**Jeanie Bourke - Re: FW: Customer Flow**

**From:** Jeanie Bourke  
**To:** JDriscol@megalink.net  
**Date:** 1/29/2015 12:59 PM  
**Subject:** Re: FW: Customer Flow  
**CC:** stephanie@smithreuter.com

FIRST FLOOR PLAN

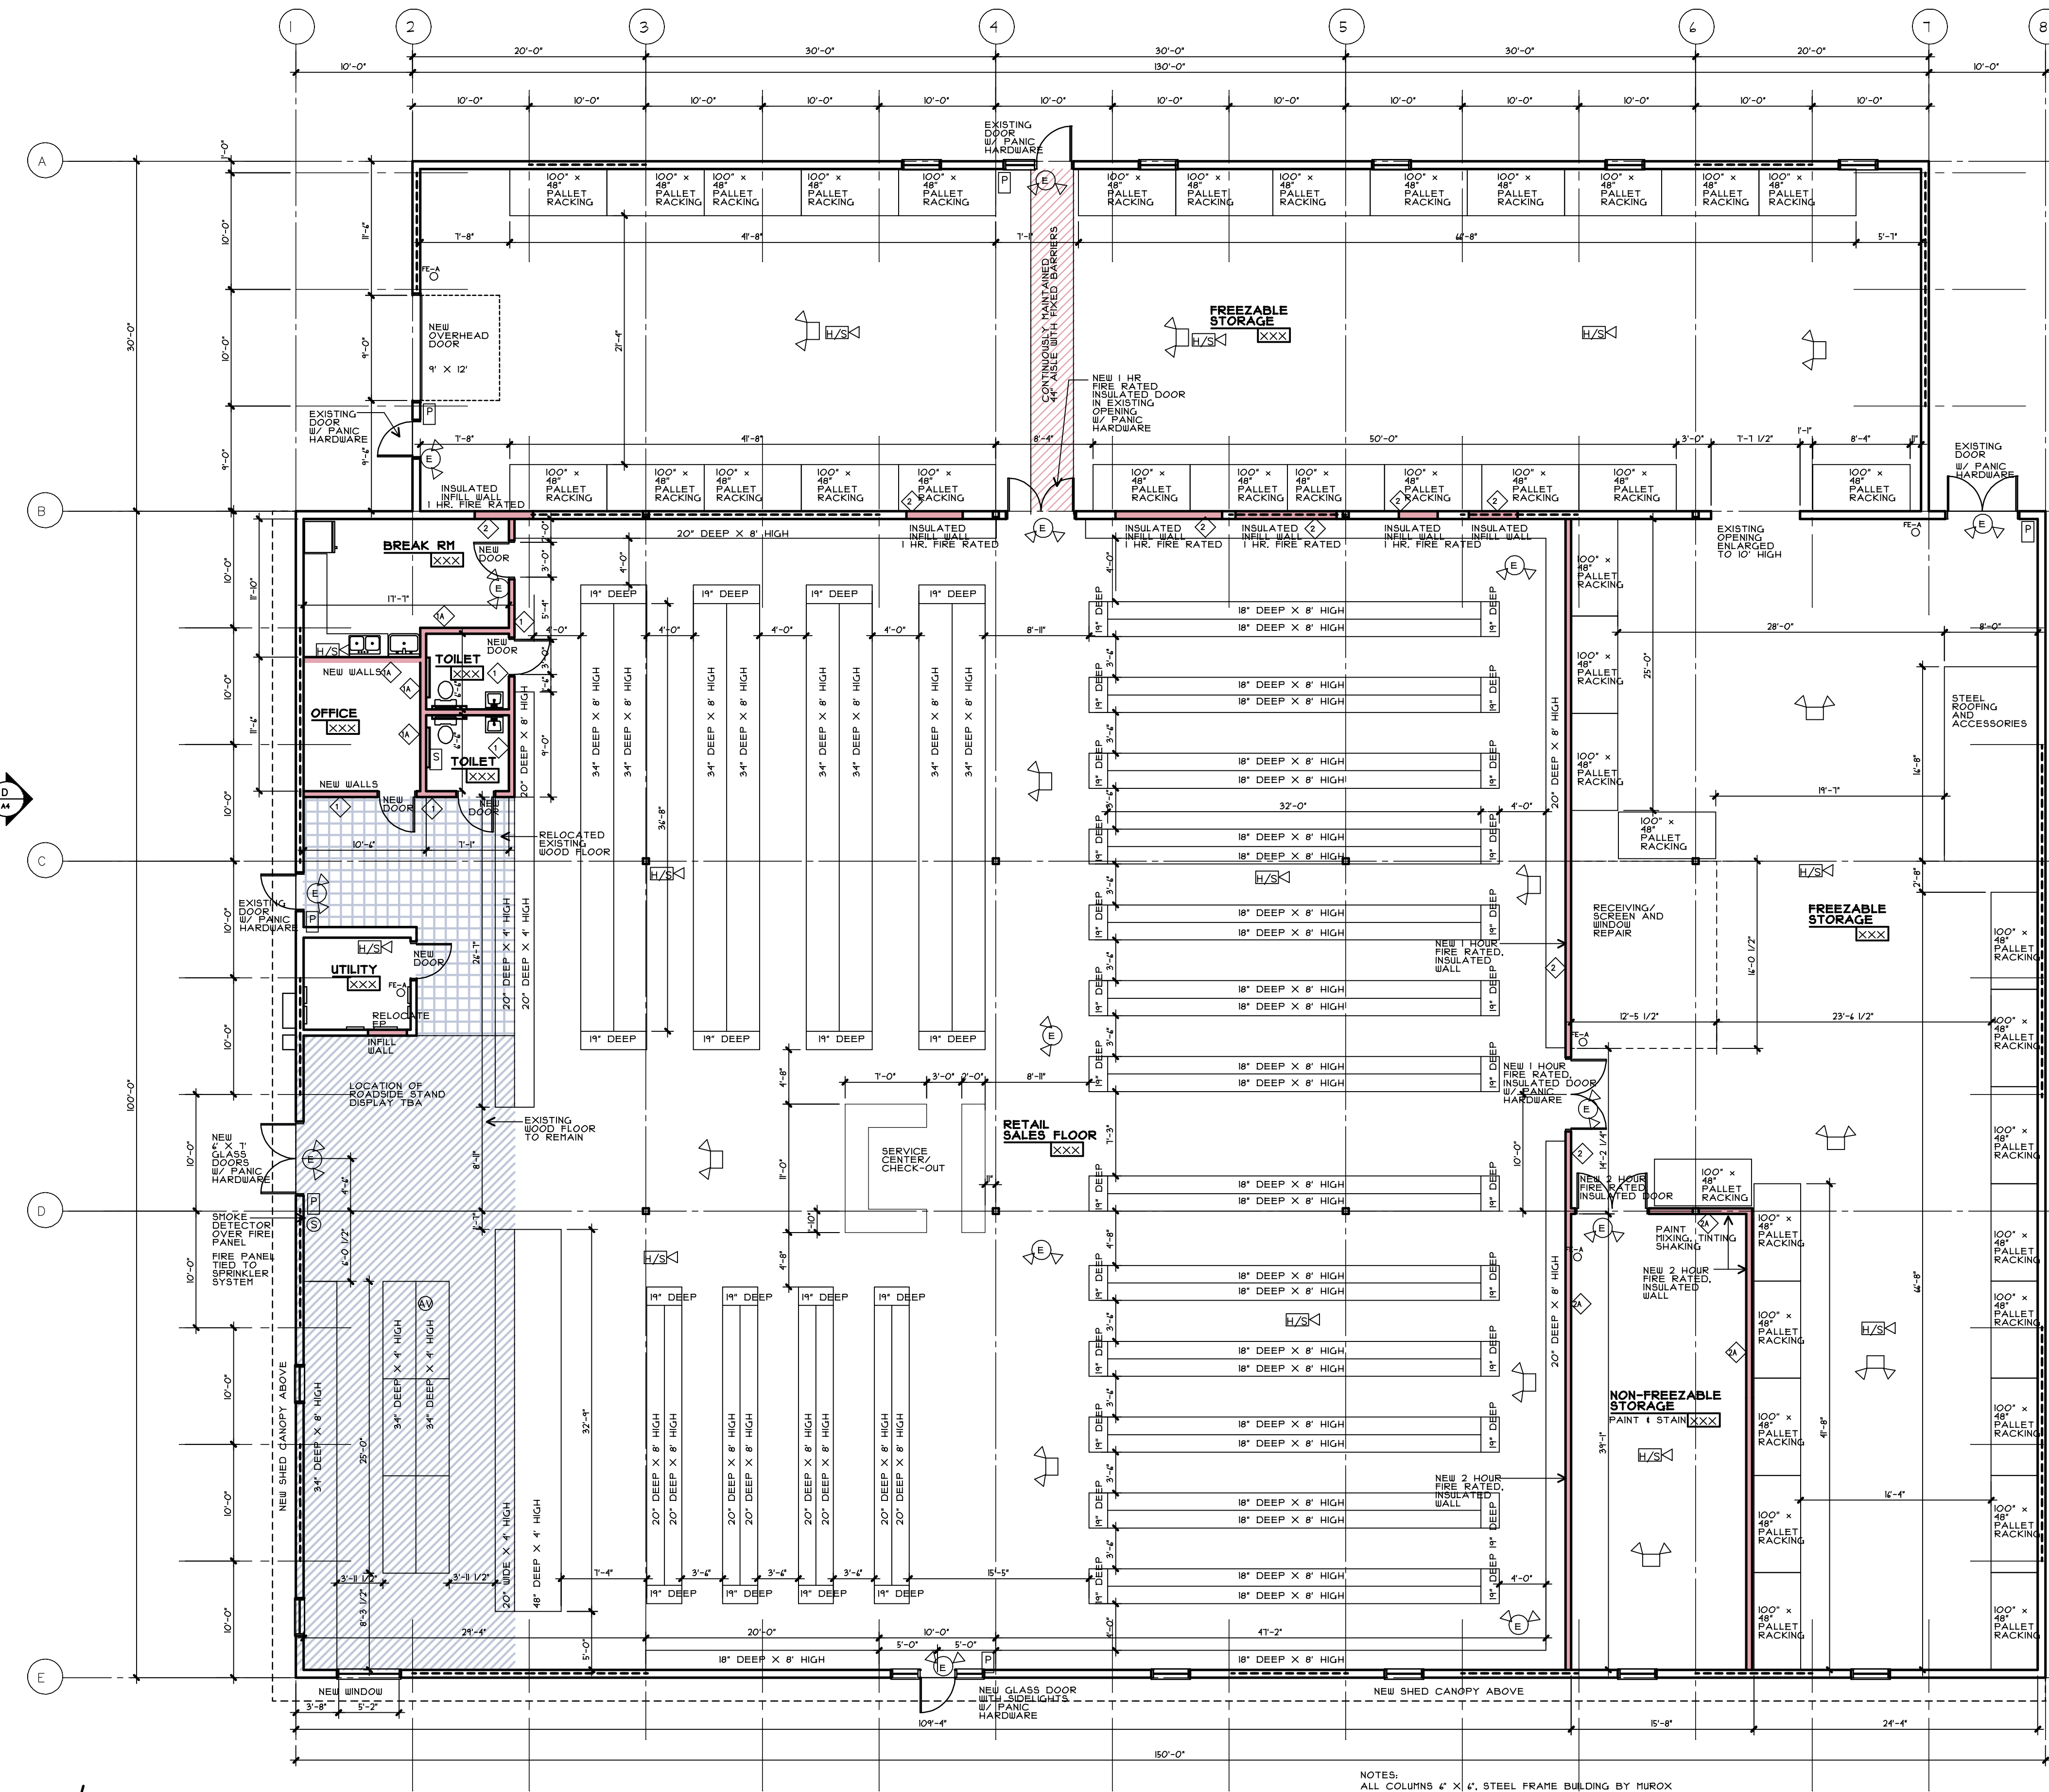
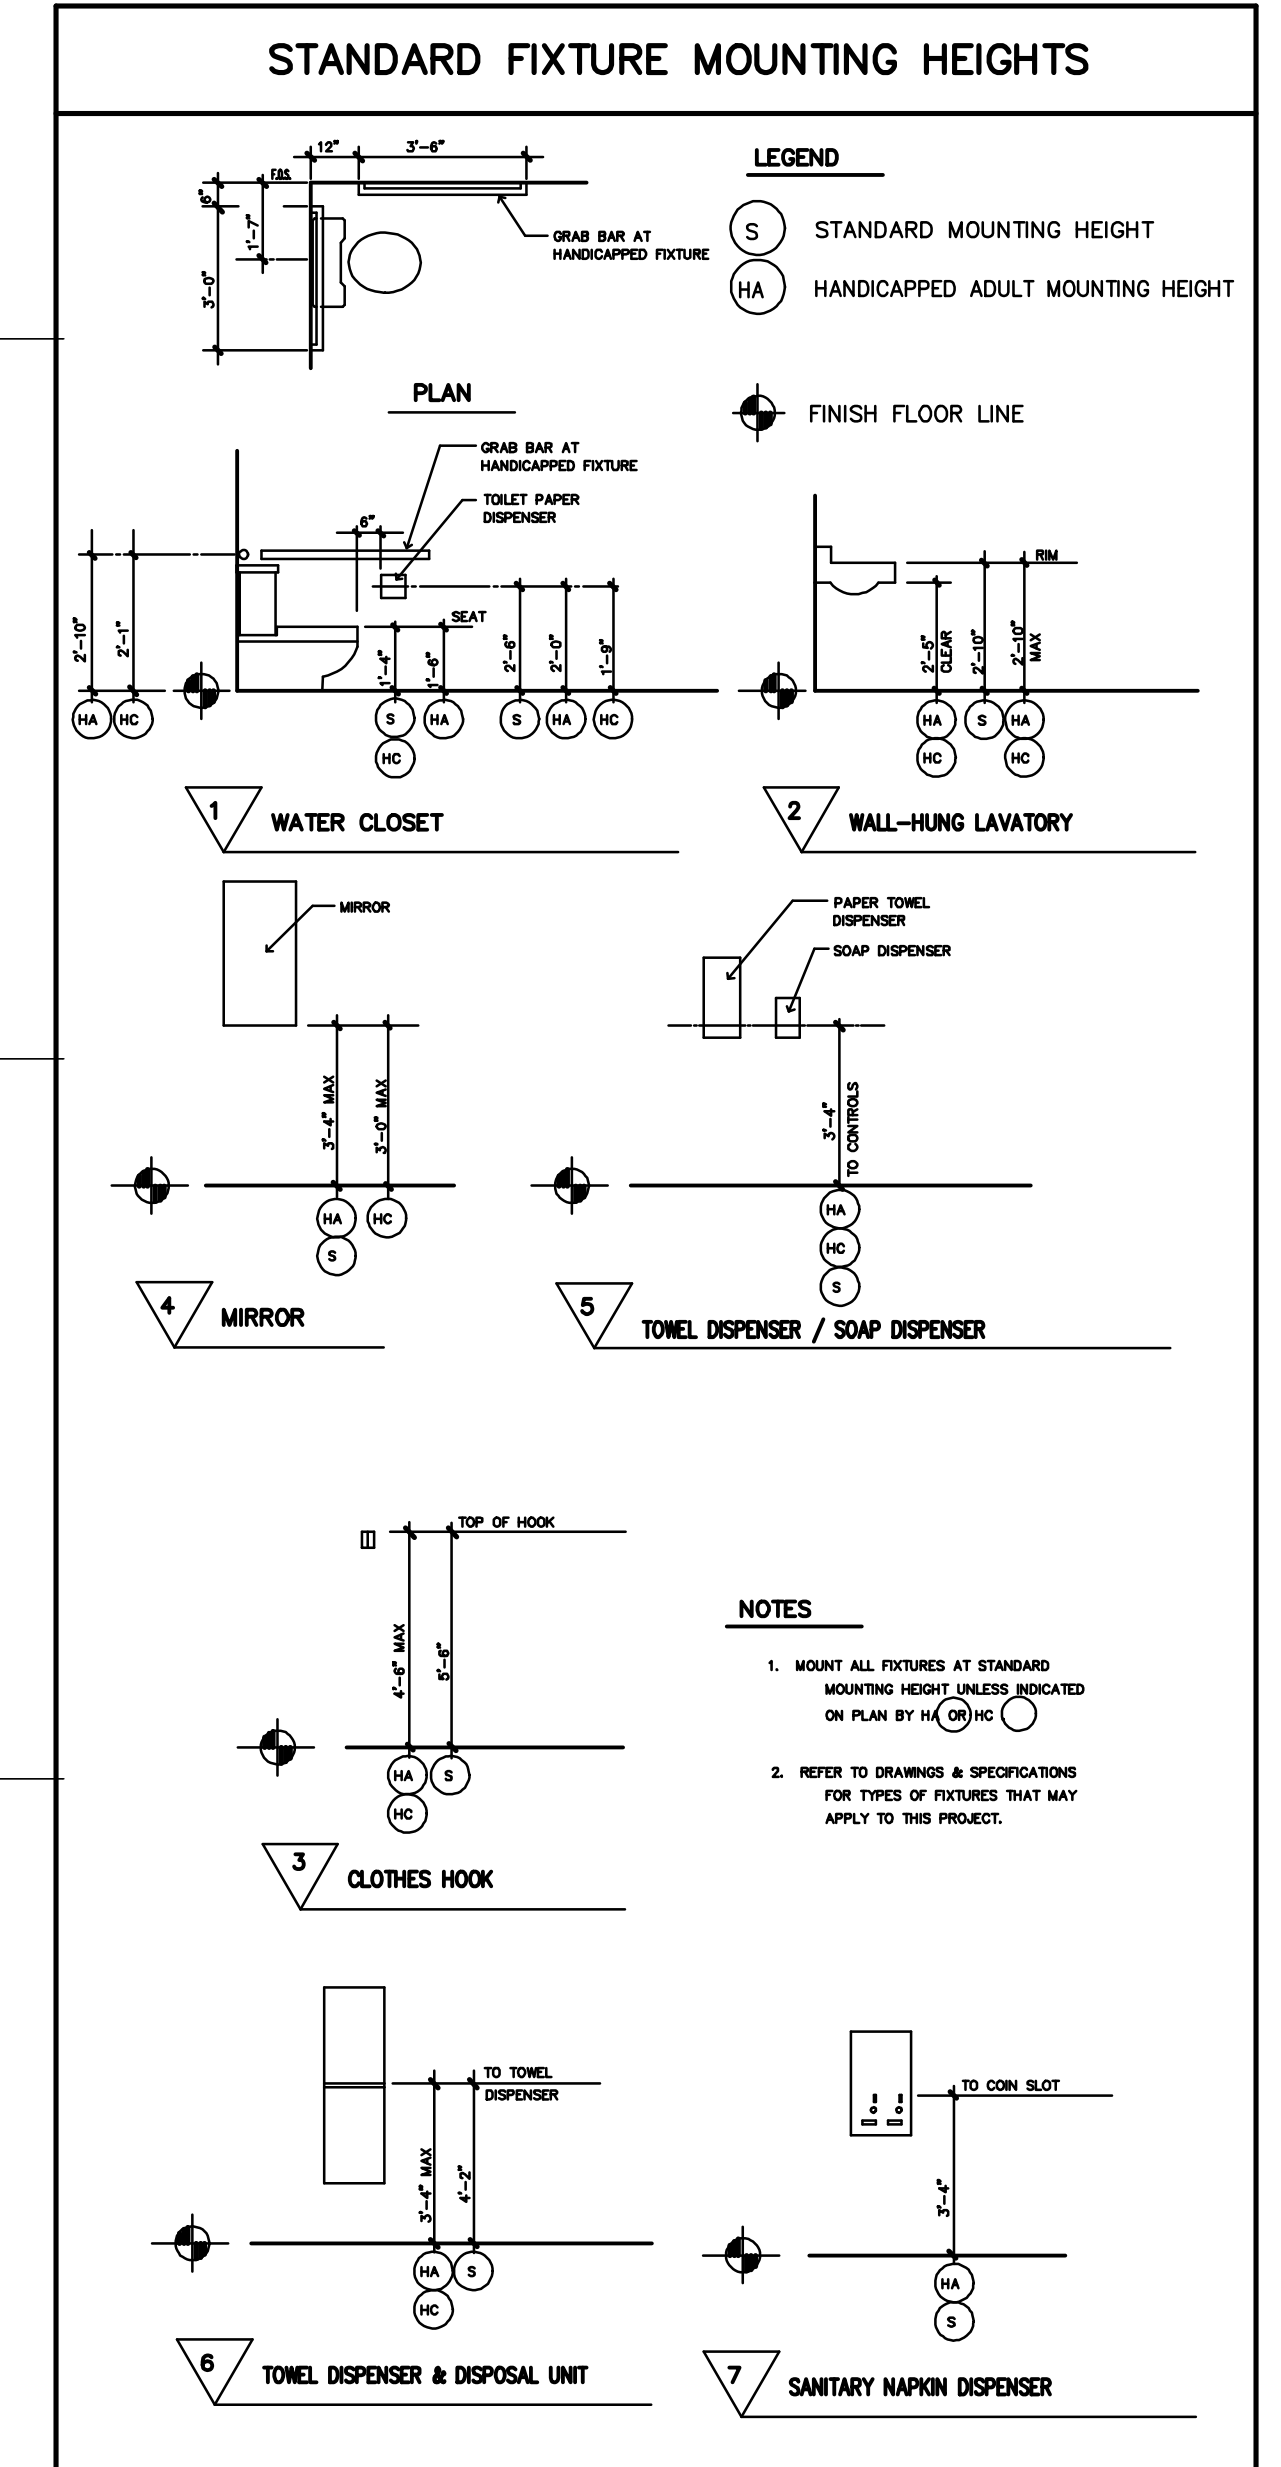
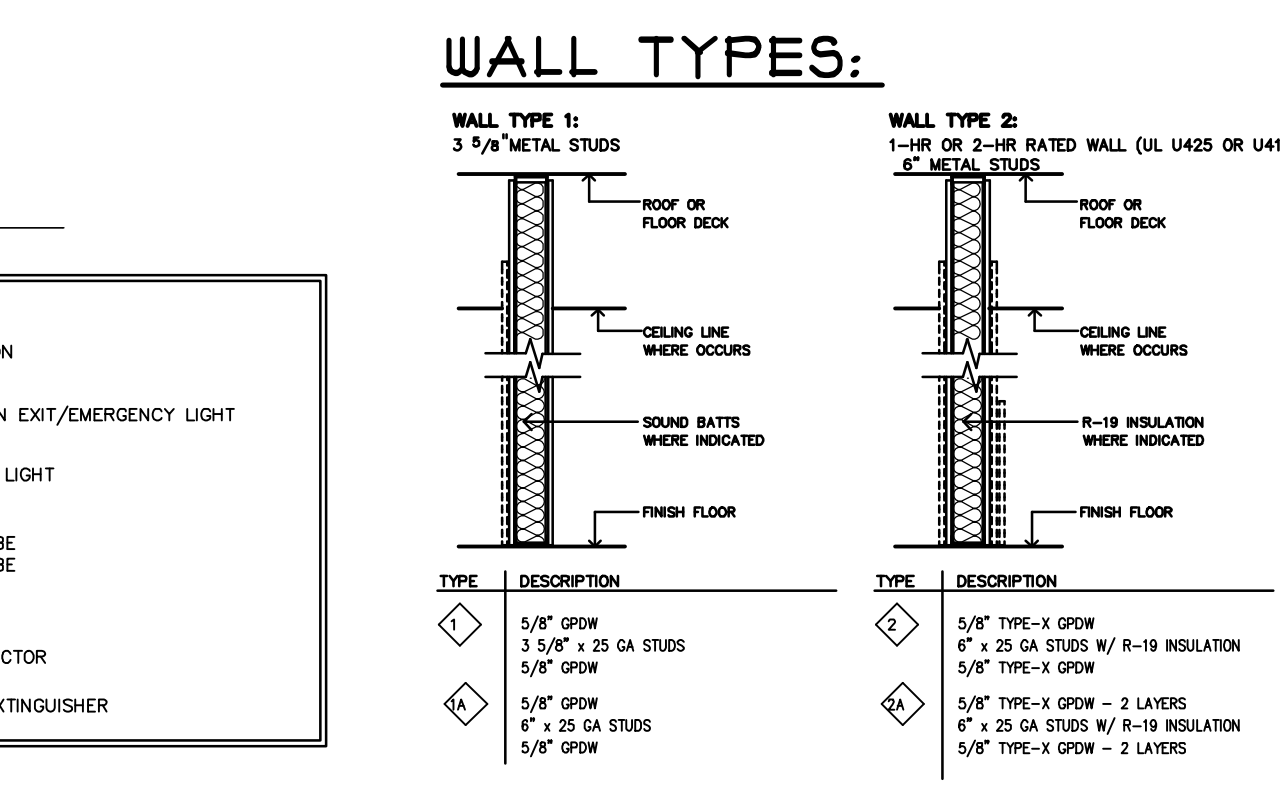
That being said, based on the business history knowledge, I will approve this permit with 2 single use bathrooms that are to be available to staff and customers. Both bathrooms will need to be accessed from the retail floor, not through a break room. Please revise the drawing to reflect this.
